**KIRKLEES METROPOLITAN COUNCIL
INVESTMENT & REGENERATION SERVICE**

**DELEGATED DECISION TO DETERMINE APPLICATIONS FOR
CONSENT, AGREEMENT OR APPROVAL REQUIRED BY CONDITION**

Reference No:	2025/44/93153/W
Site Address:	George Hotel, St George's Square, Huddersfield, HD1 1JA
Description:	Discharge of details reserved by condition 14 (construction traffic access) of previous permission 2025/91147 for refurbishment and redevelopment of the George Hotel (including partial demolition, partial reconstruction and extension) to provide 108-bedroom hotel with bar, restaurant, gym, conference facilities and ancillary facilities
Recommending Officer:	Nick Hirst

The applicant has submitted the document titled George Hotel – Traffic & Travel Plan, document number OF-01-11-002 version 03, pursuant to condition 14. K.C. Highways Development Management, who requested that the condition be imposed, have reviewed the submitted details within their consultation response dated 27/11/2025. Their comments follow:

2.1 PRIMARY ROUTES TO SITE

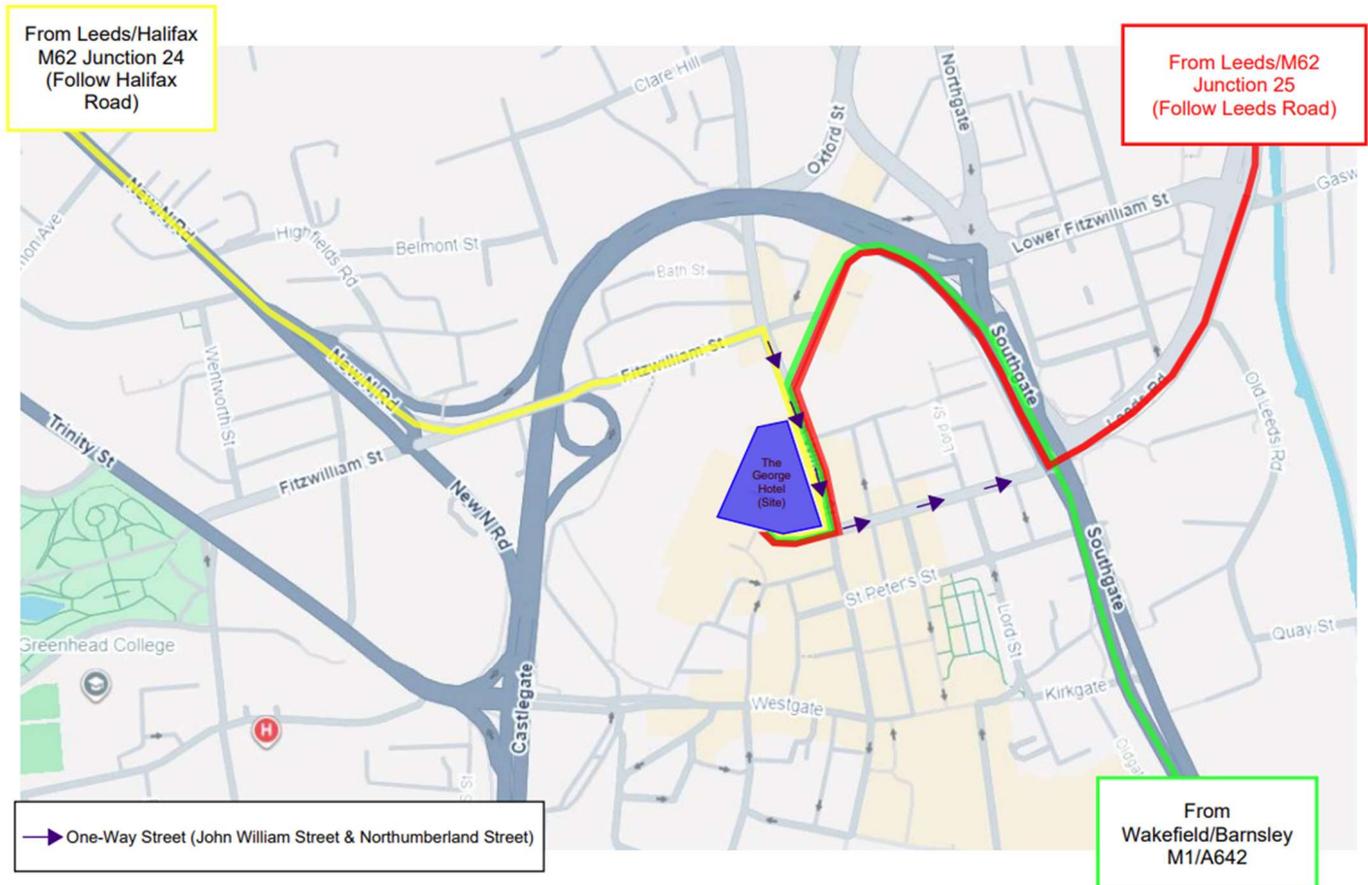
The access routes to the site is indicated on the map contained in section 2.1 - Primary Routes to the Site and this is acceptable.

2.2 JOHN WILLIAM STREET TRAFFIC MANAGEMENT

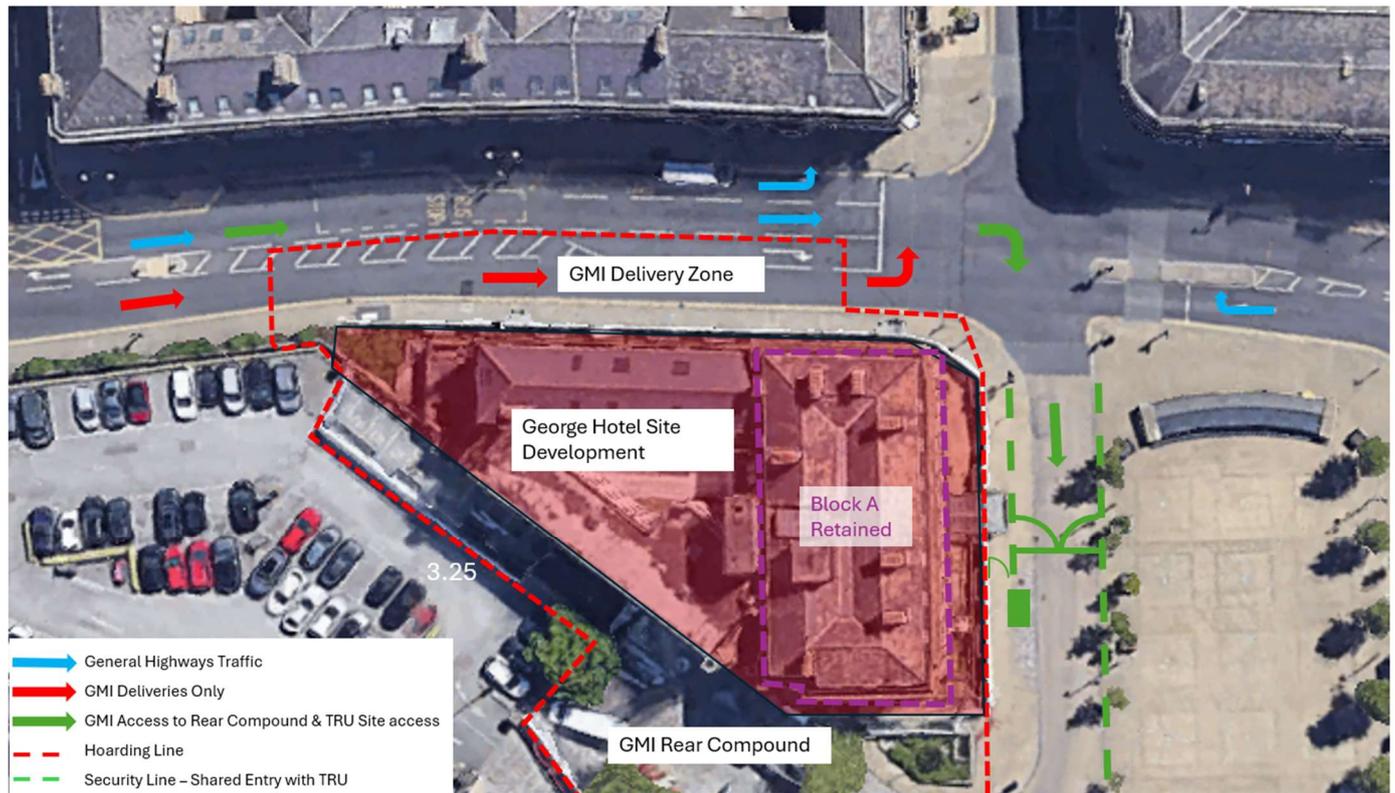
The access points into the site and the loading area are shown on the photograph included in section 2.2 - John William Street Traffic Management and are acceptable. It should be noted that the correct licencing and agreements with Kirklees as the Local Highway Authority will need to be arranged prior to the temporary closure of John William Street.

2.7 MAINTAINING & PROTECTING THE HIGHWAY

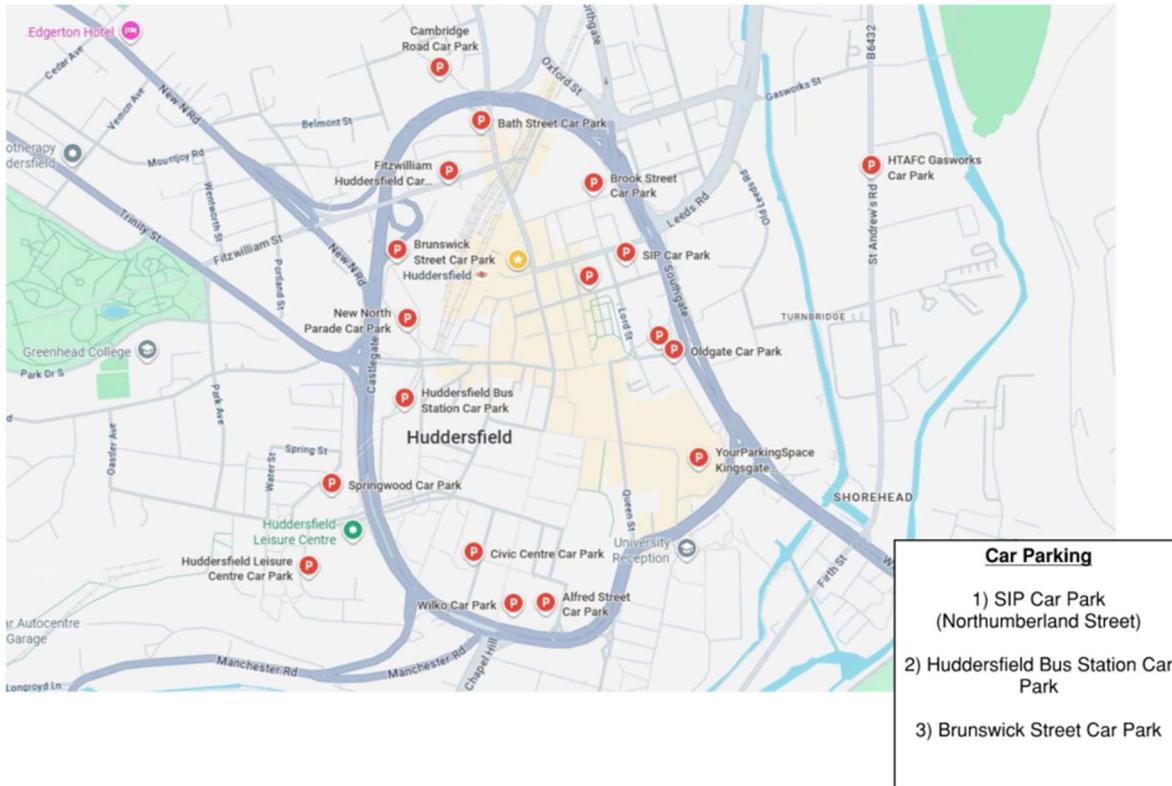
Details of the use and retention of wheel washing facilities and the use of heavy duty track matting to protect the surface of the highway is included in section 2.7 – Maintaining and Protecting the Highway and this is acceptable.
